WEST SUSSEX COUNTY COUNCIL CONSULTATION

TO:	Arun District Council FAO: Anita Gardner
FROM:	WSCC - Highways Authority
DATE:	4 December 2020
LOCATION:	Croft Works 52 Mill Lane Rustington BN16 3JN
SUBJECT:	R/197/20/OUT Outline application with some matters reserved for the demolition of existing dilapidated storage buildings & erection of 2 No. detached 3-bedroom chalet bungalows with associated car barns, gardens, car parking & landscaping (resubmission following R/117/20/OUT). This site is in CIL Zone 4 & is CIL Liable as new dwellings. More information received.
DATE OF SITE VISIT:	n/a
RECOMMENDATION:	Advice
S106 CONTRIBUTION TOTAL:	n/a

SITE PLAN 1:250

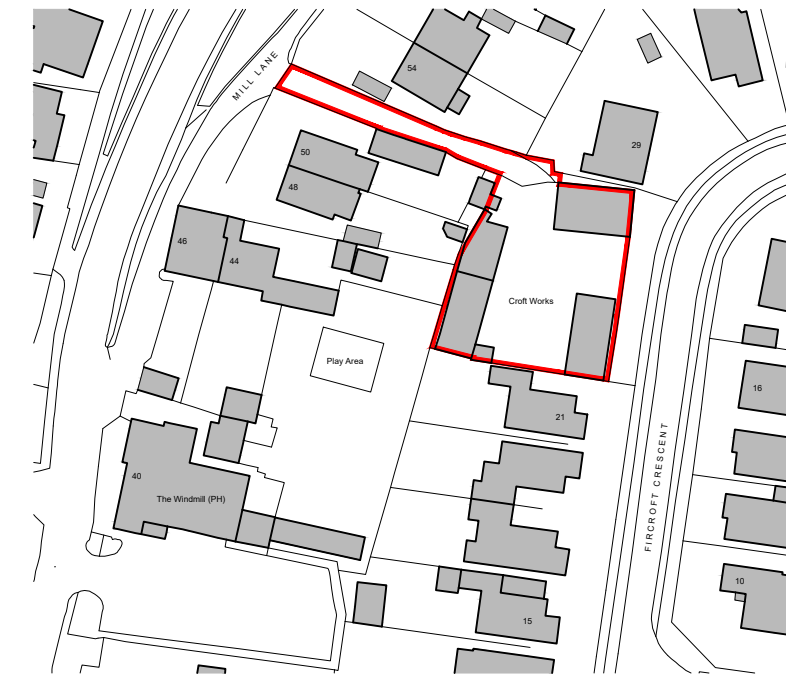
The Applicant proposes a parking provision of 6 space(s).

Arun parking standards state that, 4 spaces plus 20% visitor parking spaces are needed for such a development.

The applicant has shown that both houses will benefit from 3 parking spaces each and though not annotated as visitor parking space the LHA would anticipate that in practice these could accommodate such a provision.

Upon inspection of the plans and supporting documents the LHA concludes that the applicant proposes to supply a NIL parking provision. The LHA wishes to advise the following,

The Local Highways Authority (LHA) would not anticipate that future occupiers of the dwelling would be reliant on the use of a private motor vehicle. As a result, the LHA would like to see the implementation of cycle storage space. Details of which can be secured with a suitably worded condition found below.

No part of the development shall be first occupied until covered and secure cycle parking spaces have been provided in accordance with plans and details **to be** submitted to and approved by the Local Planning Authority.

No part of the development shall be first occupied until the electric vehicle charging space(s) have been provided in accordance with plans and details **to be** submitted to and approved by the Local Planning Authority.
